DECISION DELEGATED TO HEAD OF PLANNING

Application No: H02-1028-23 **Applicant:** Mr S Hutson
Proposal: First Floor Rear Extension
Location: 75 South Street Crowland Peterborough
Terminal Date: 19th January 2024

PROPOSED FIRST FLOOR PLAN

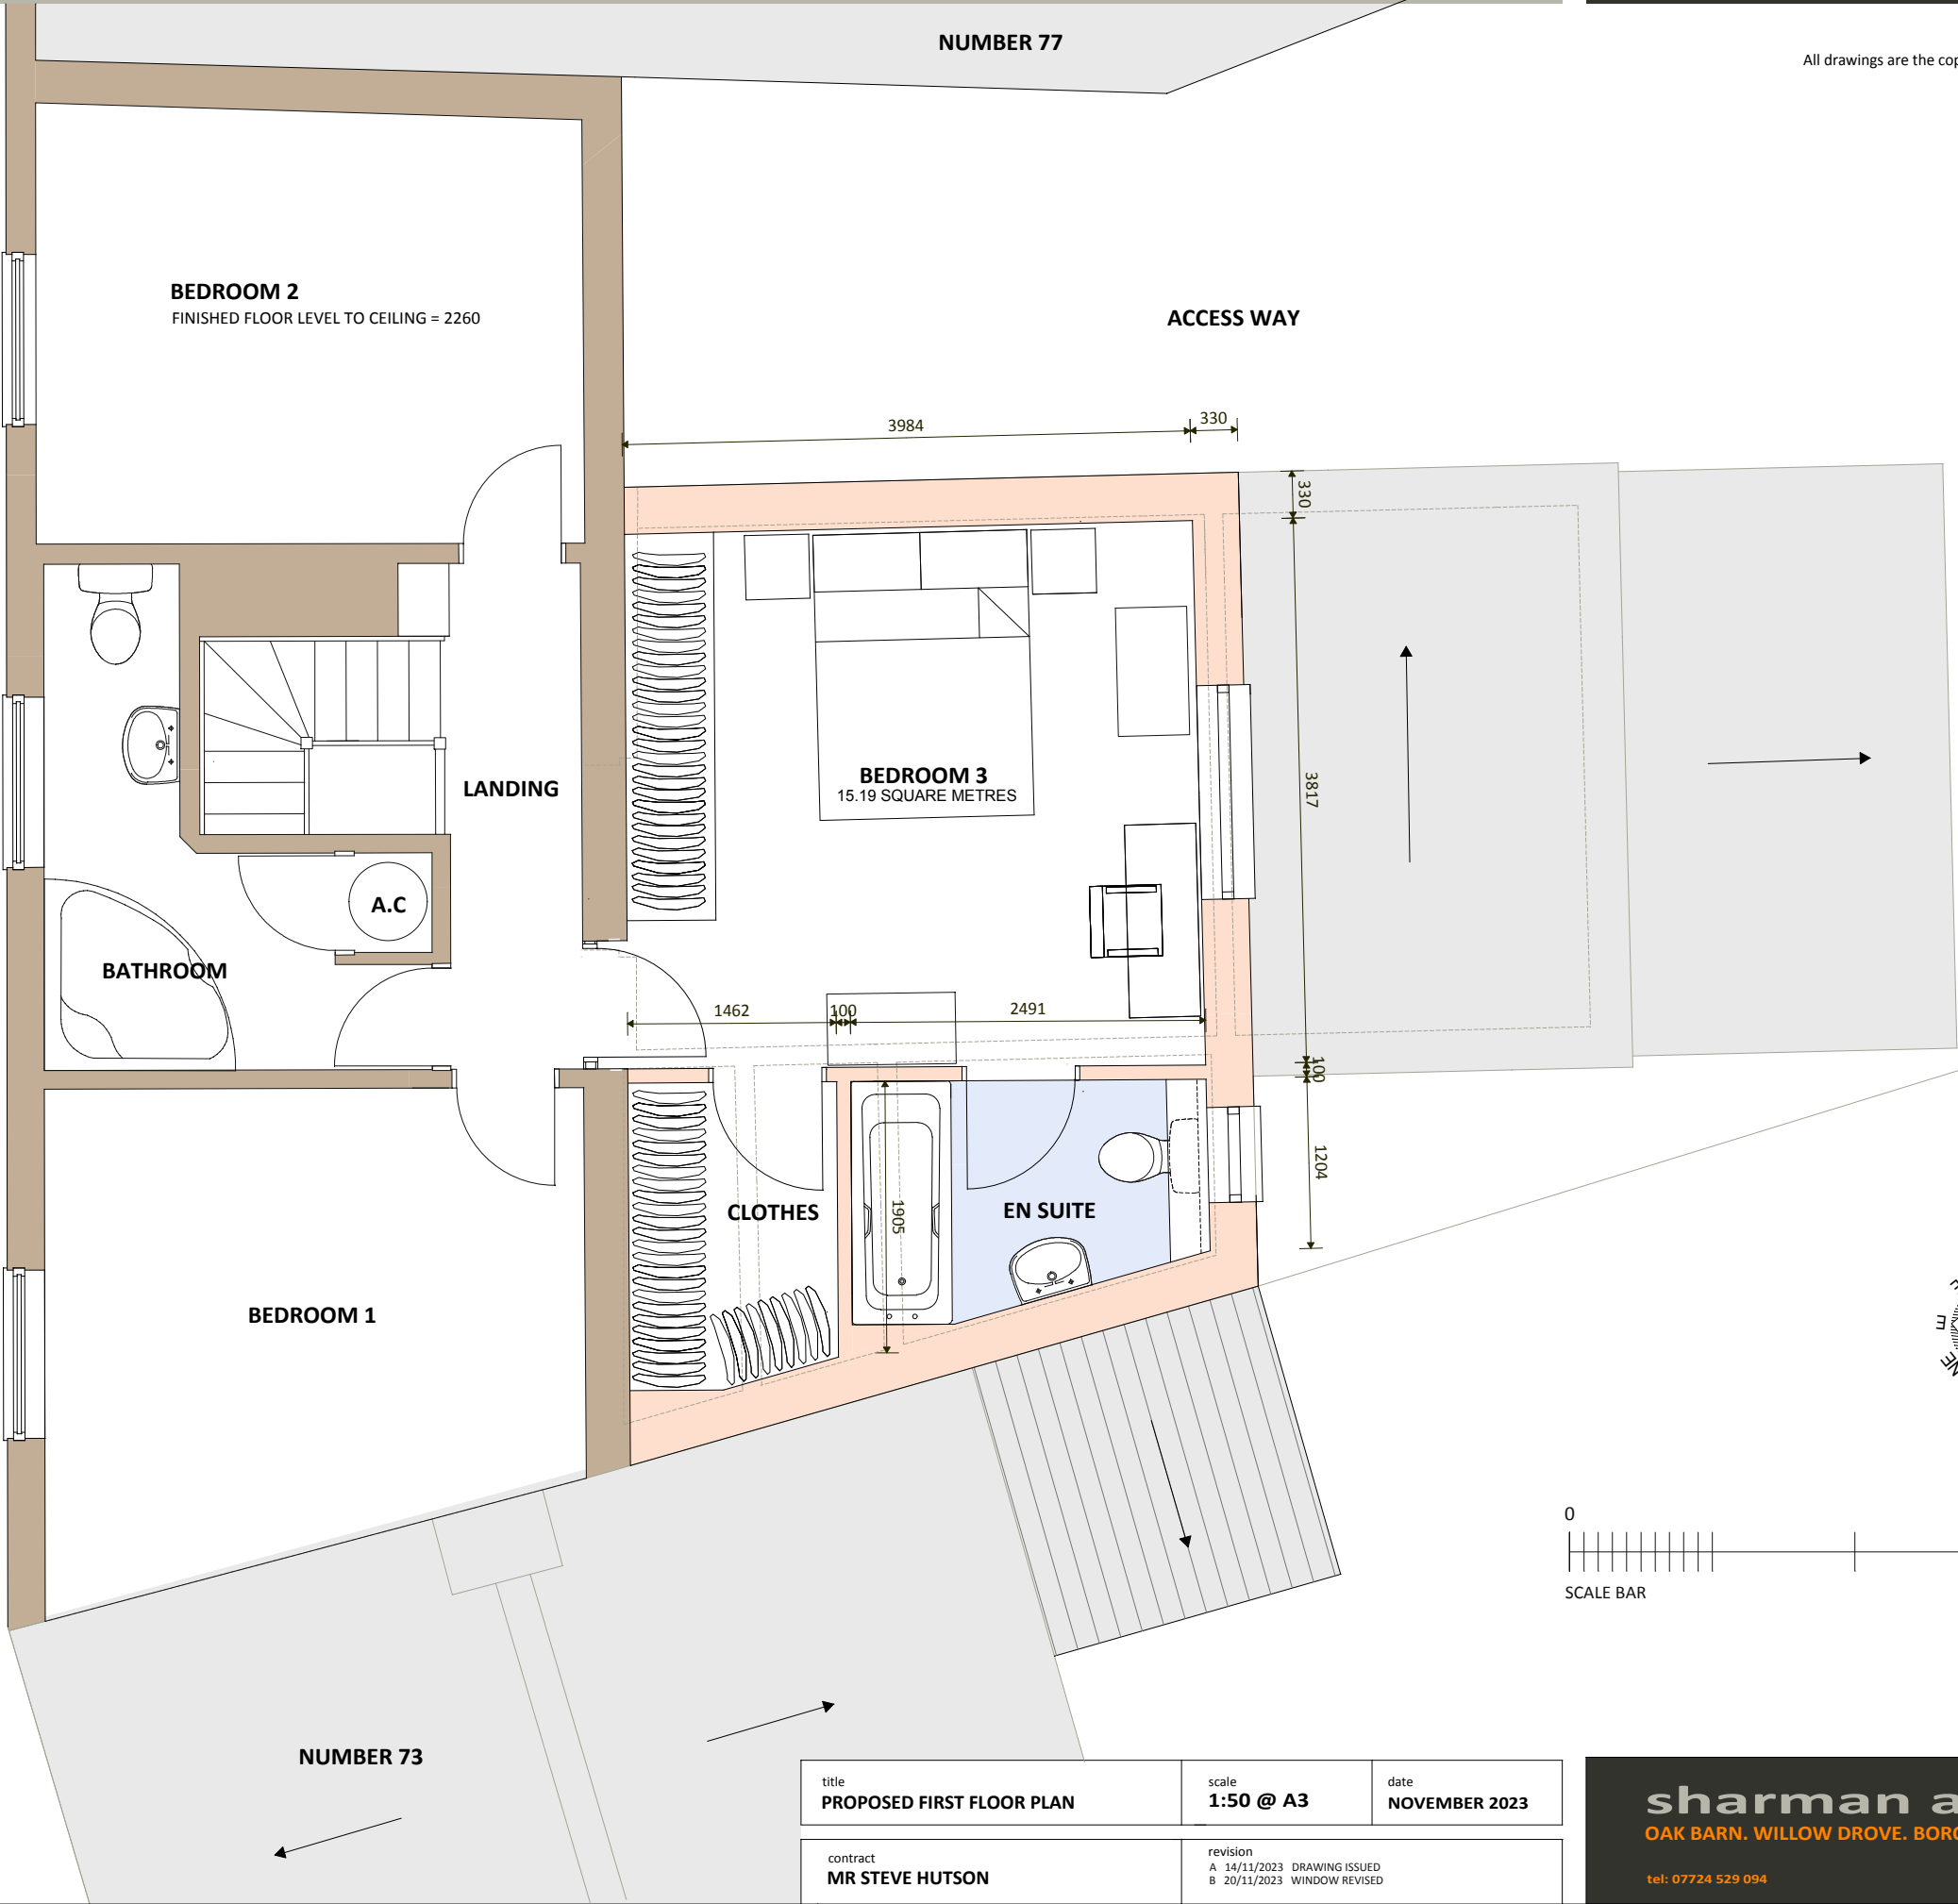
The extension shall protrude from the rear by around 4300mm and has a total width of 5700mm, this allows it to fit on the single storey rear section whilst also appearing subservient due to its smaller ridge height sitting just higher than eaves of the existing house and not running the full length or width. As mentioned, they are proposing to incorporate a flat roof on the proposal, whilst flat roofs are not commonly favourable due to it being situated at the rear it should not harm the street scene or locality, additionally, other dwellings feature a similar rear extension design with a flat roof allowing room for an extra bedroom etc. Therefore, this extension and its size allows it to appear subservient and proportionate whilst providing adequate extra floor space for a proposed bedroom with an en-suite and walk in wardrobe.

The extension proposes two windows on the rear elevation, one of which shall be obscure glazed due to the nature of the room acting as an en-suite with the other being a bedroom. This bedroom window shall face directly to the rear and could potentially provide views into either side neighbours rear gardens, however, following a site visit and further research, it is apparent that both neighbours have windows to the rear that also act as bedrooms and therefore any issue that could arise here would already be in place with the existing neighbours, furthermore, a neighbouring comment has been submitted in support of this application further reiterating that this scheme would be acceptable despite this issue being identified. Any view it may provide would appear to be oblique and not materially worse than how it is currently, alongside this as it is in a built up terraced area there is overlooking throughout the estate and area already due to the nature of the land. This would therefore be acceptable in terms of overlooking and potential loss of privacy.

title PROPOSED ELEVATIONS	scale 1:100 @ A3	date NOVEMBER 2023
contract MR STEVE HUTSON	revision A 17/11/2023 DRAWING FIRST ISSUED B 20/11/2023 WINDOW REVISED

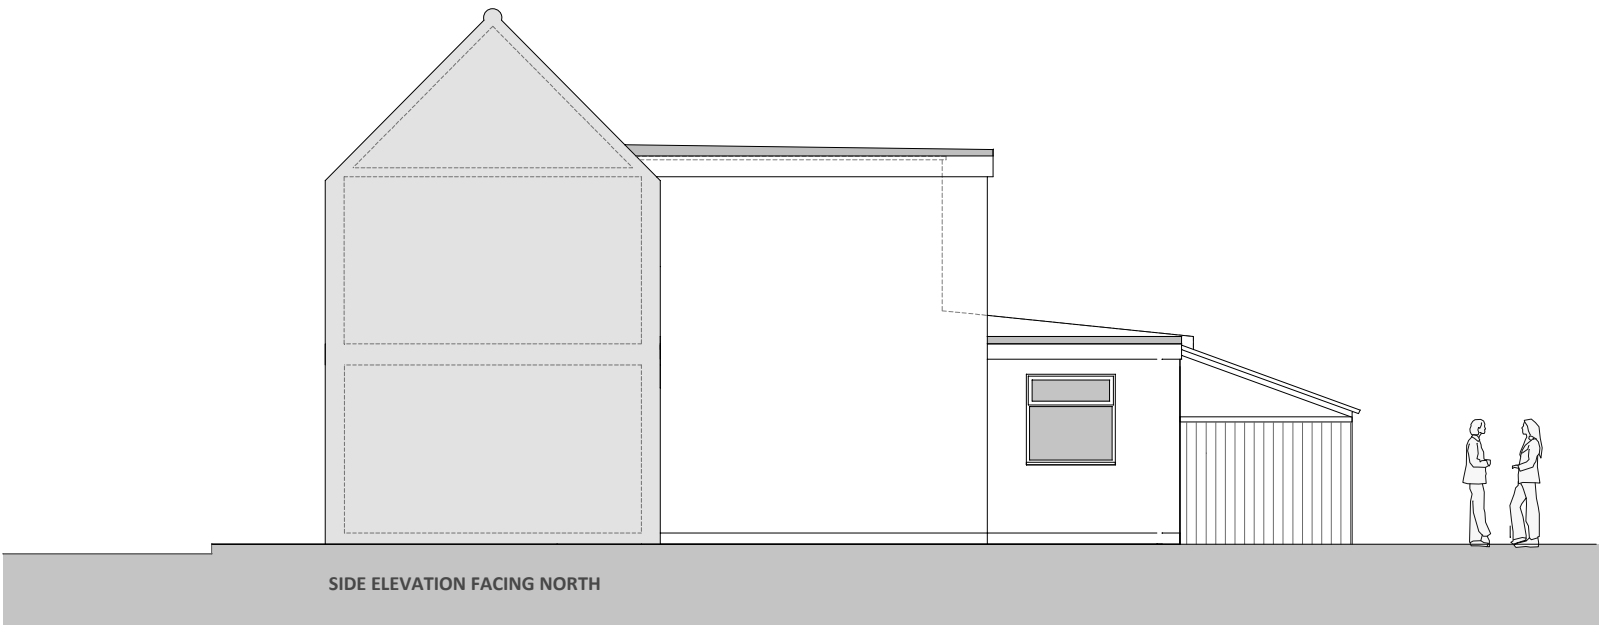
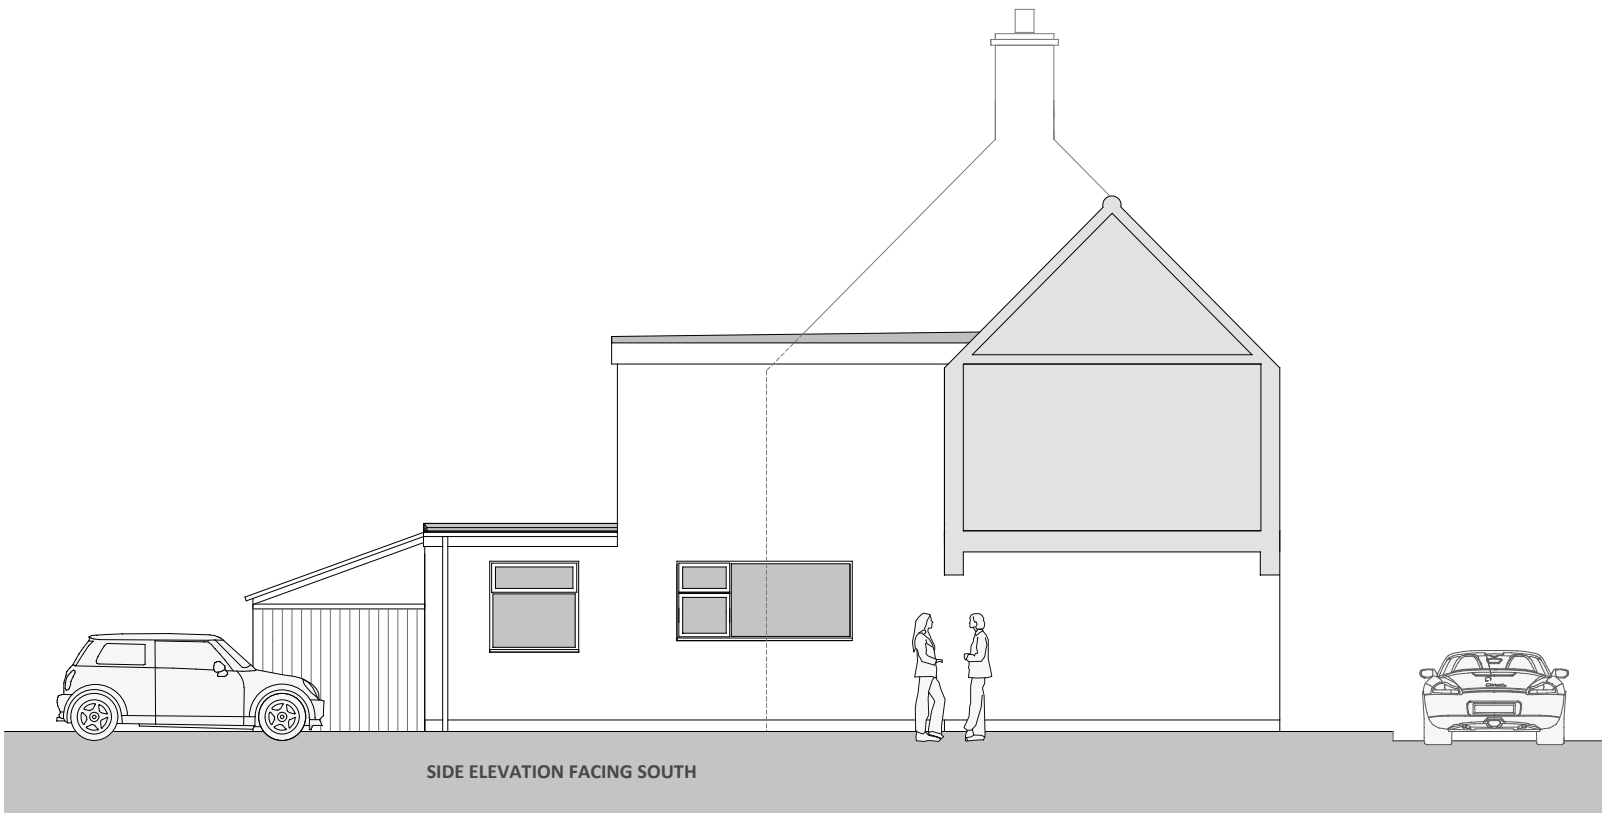
The proposal aims to use similar materials for the most part, the walls shall be a rendered block work to match the existing and brown uPVC windows, also to match. The existing two storey building section is made from concrete roof tiles with the single storey section being a flat roof with a felt finish, they proposed to use a grey glass reinforced plastic (GRP). Whilst this roof material will not match the existing roof tiles, it will look similar to the single storey roof of the neighbouring property and therefore will not look out of character, alongside this, as it will be at the rear it should not harm the street scene or locality.

| title<br>EXISTING & PROPOSED ROOF PLANS | scale<br>1:100 @ A3                     | date<br>NOVEMBER 2023 |

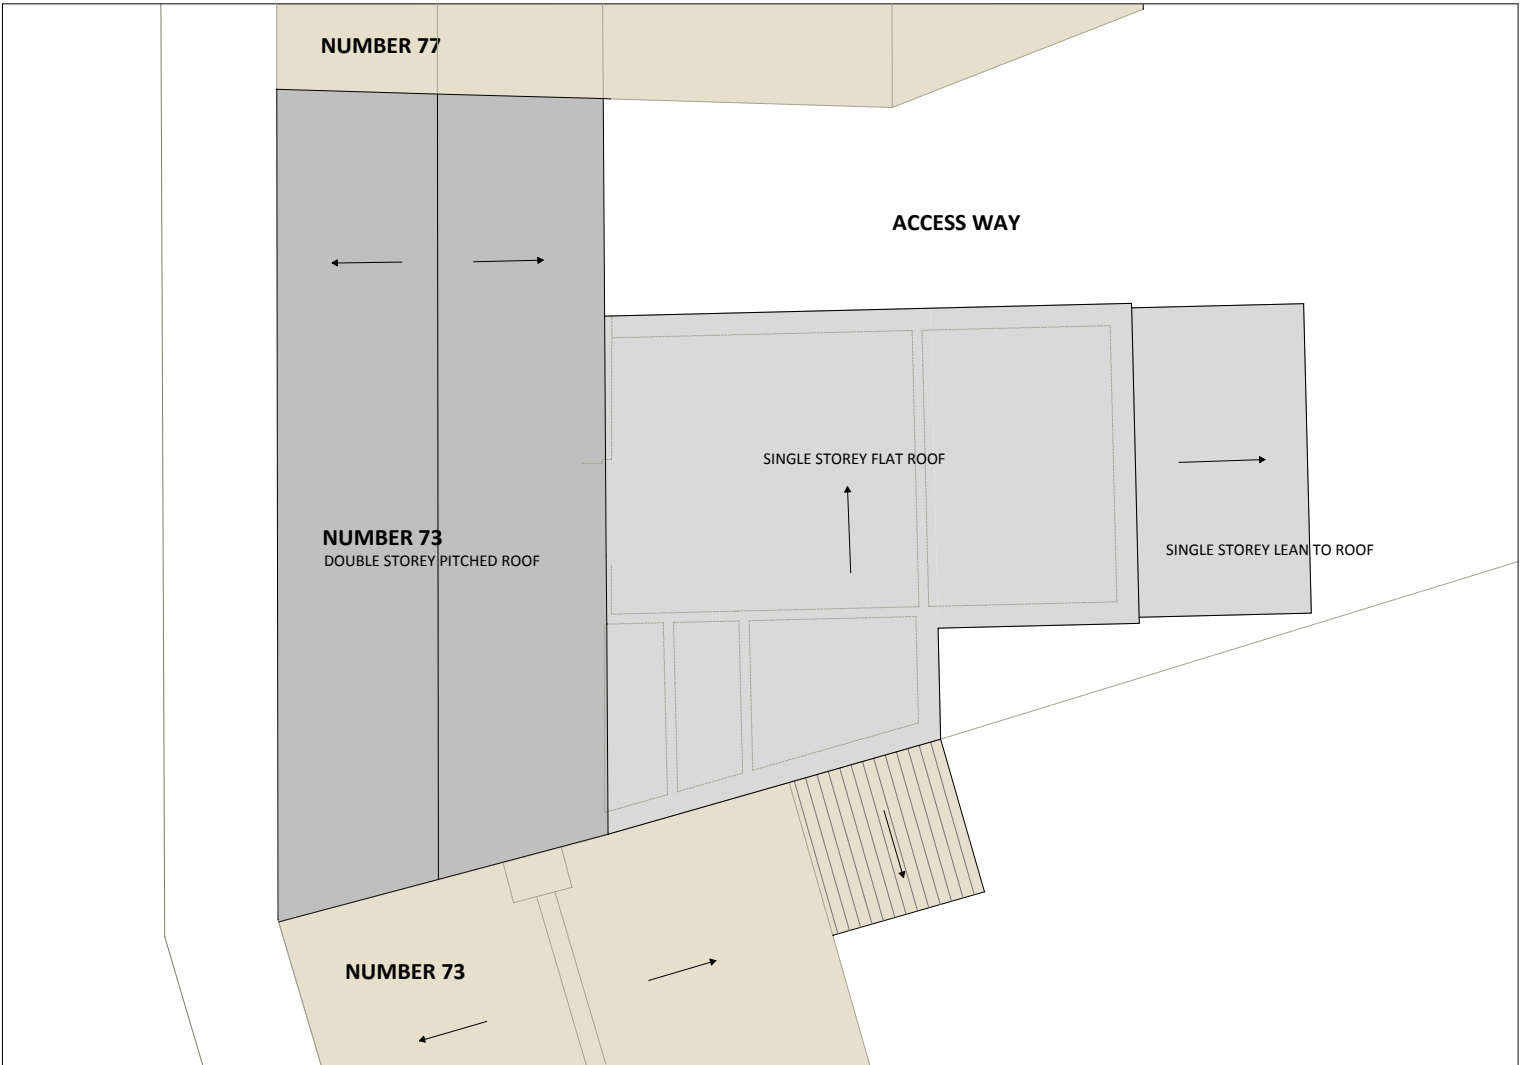
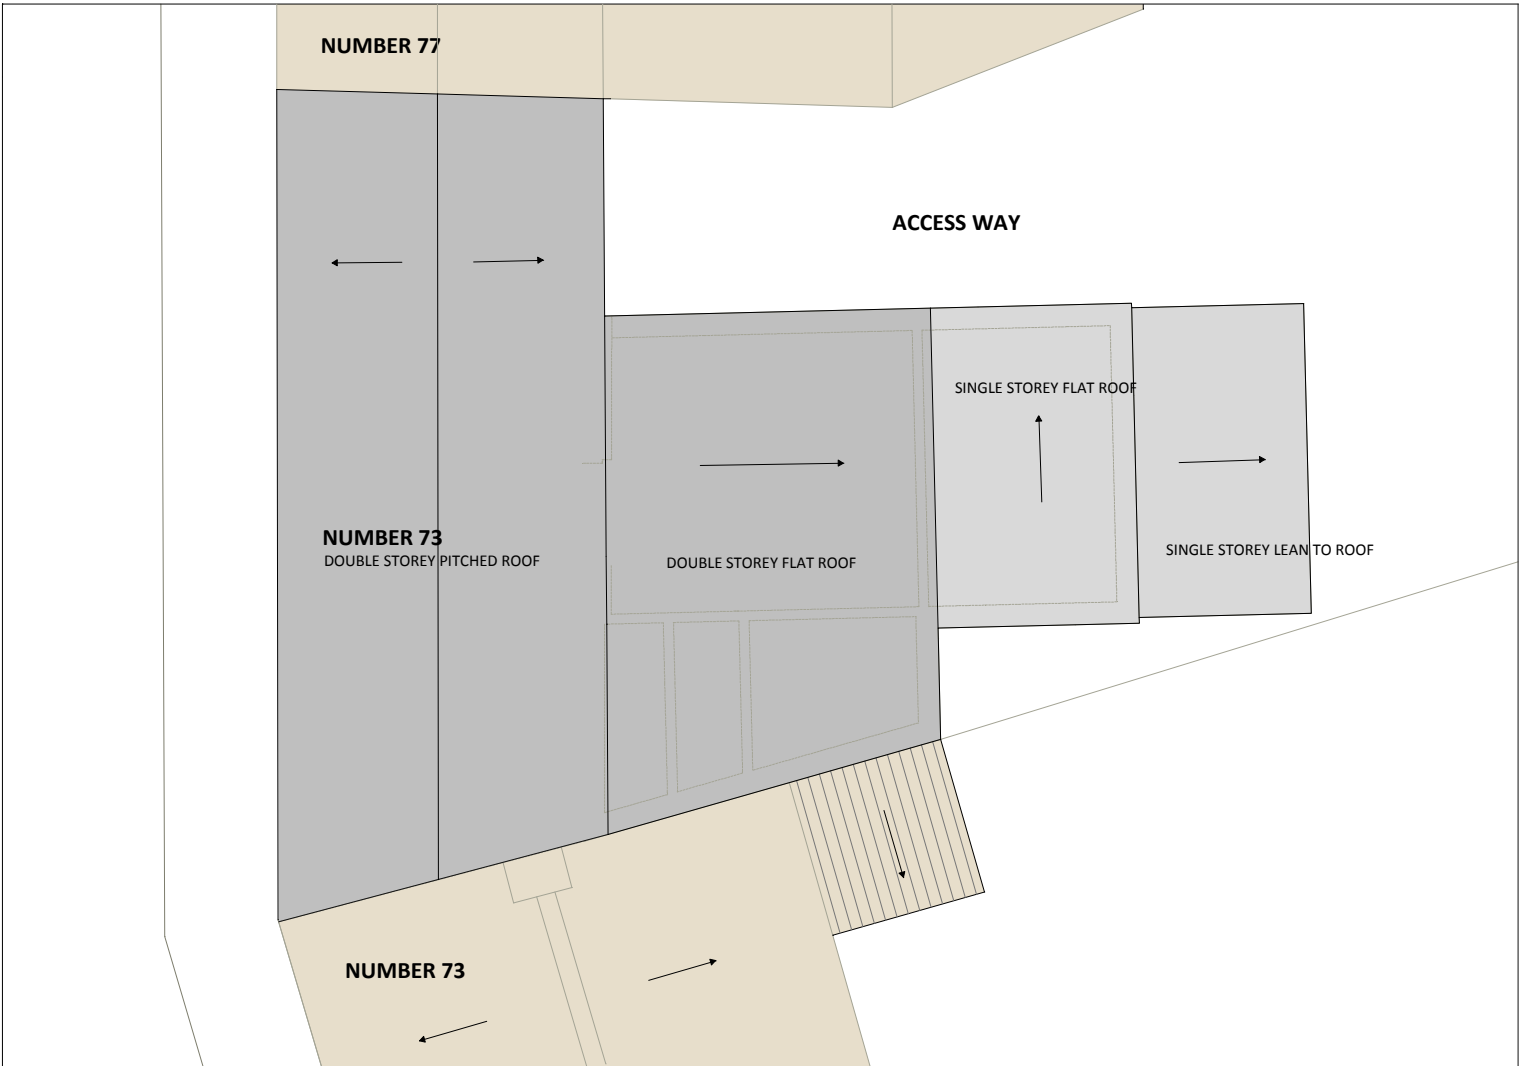
The proposal will feature a flat roof meaning the ridge height will come up slightly higher than the eaves of the existing house, therefore, it will shall not be any higher than the host dwelling. Due to this and the positioning of the dwelling this means that no shadow should be cast onto the neighbouring plots and therefore would not result in a loss of light in this instance.
